HAY CREEK VALLEY

FINAL GRADING & EROSION CONTROL PLANS

SEPTEMBER 2023

EPC STORMWATER REVIEW COMMENTS IN ORANGE BOXES WITH BLACK TEXT

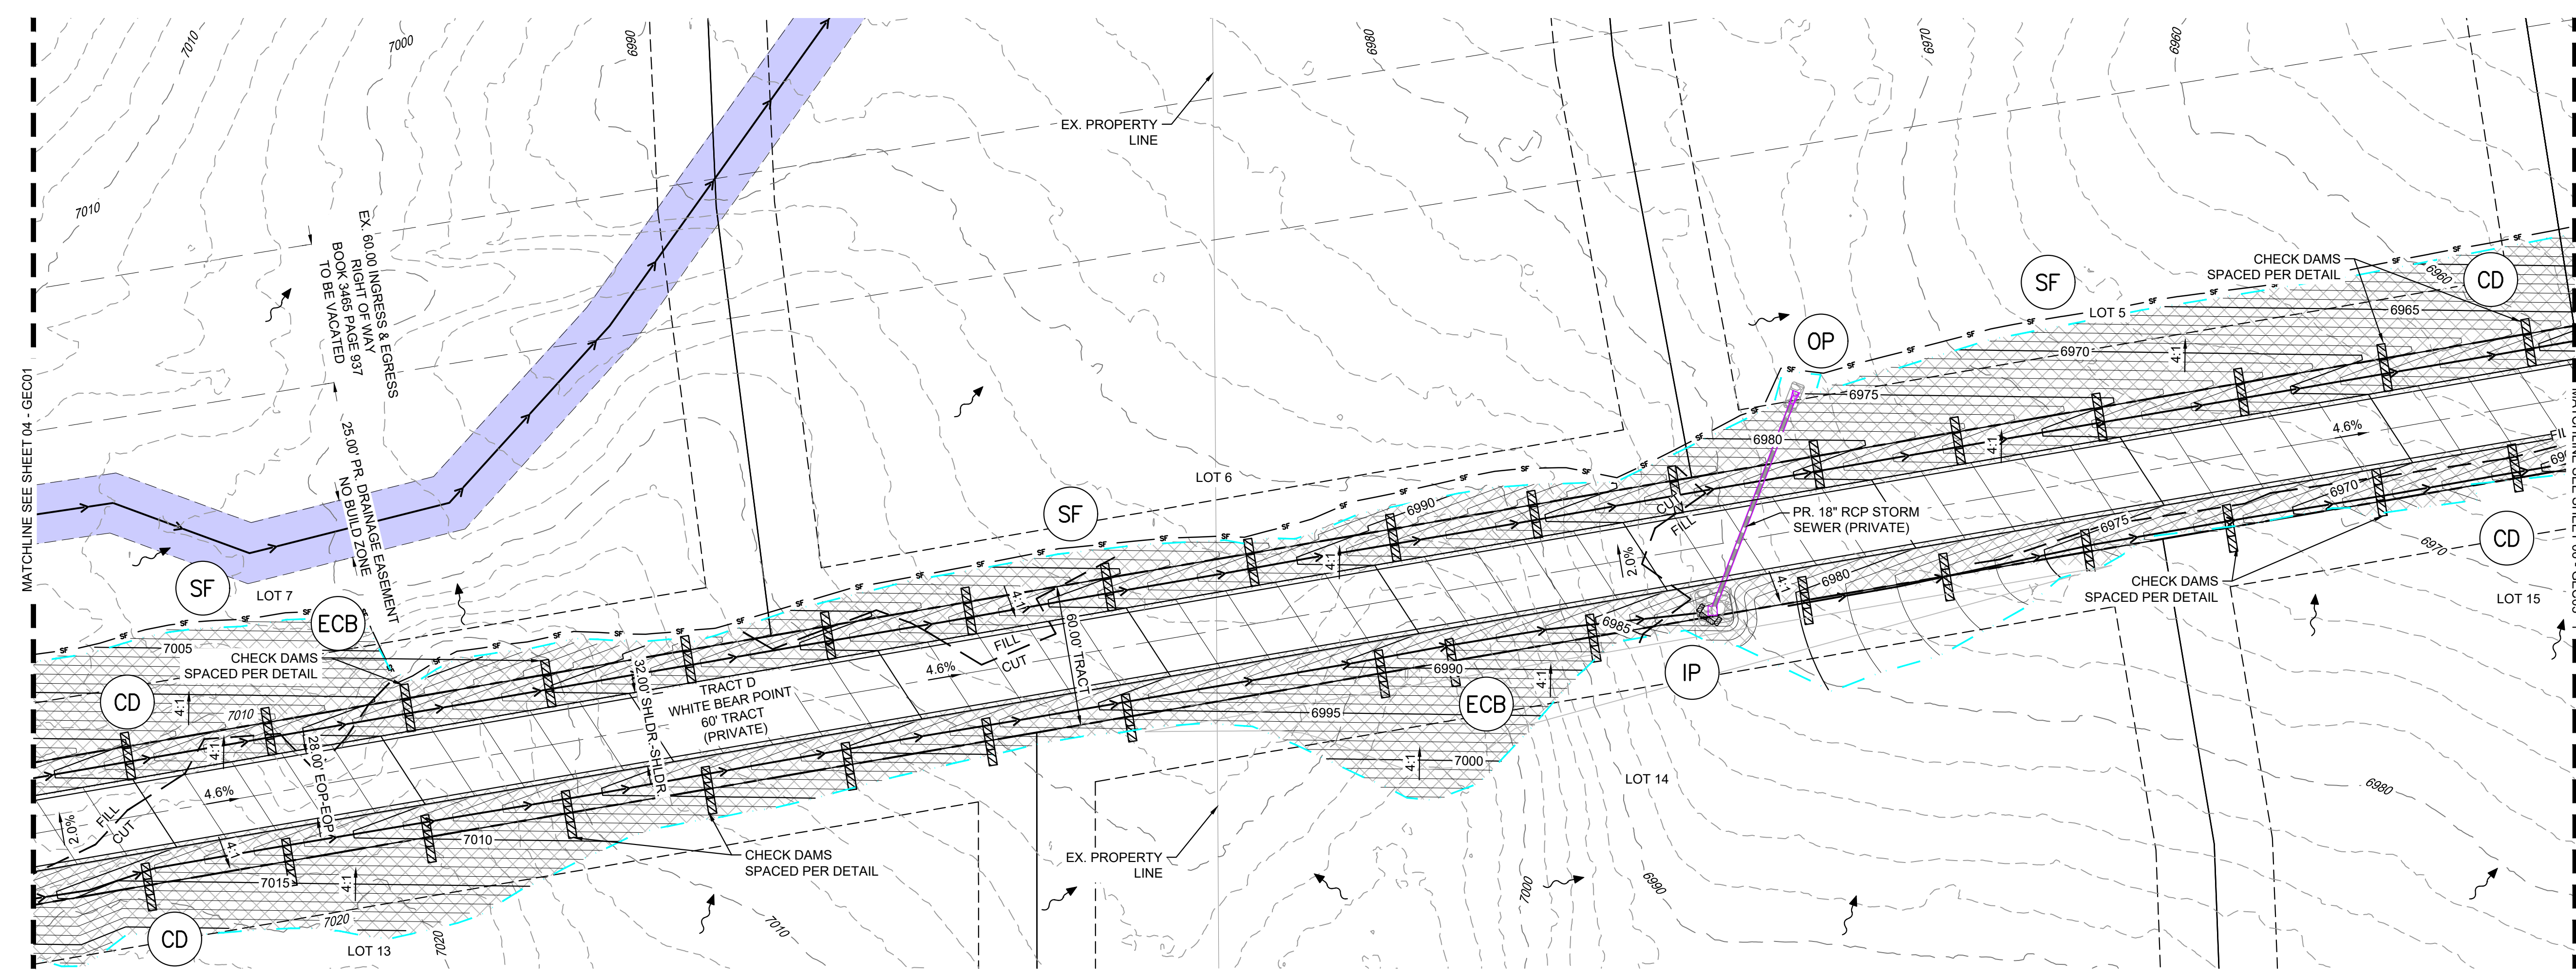
GEC Checklist Item j - show FEMA floodplain areas in legend and on plans, clearly define.

This rock hatching is labeled as VTC in the legend, will these proposed ditches be riprap lined? If so add to the legend

seeding/mulching also should be included in the final stage and in the legend. All disturbed areas should be seeded.

Show check dams in legend.

GEC Checklist Item ee - Plan must be certified by a Colorado Registered PE prior to approval.
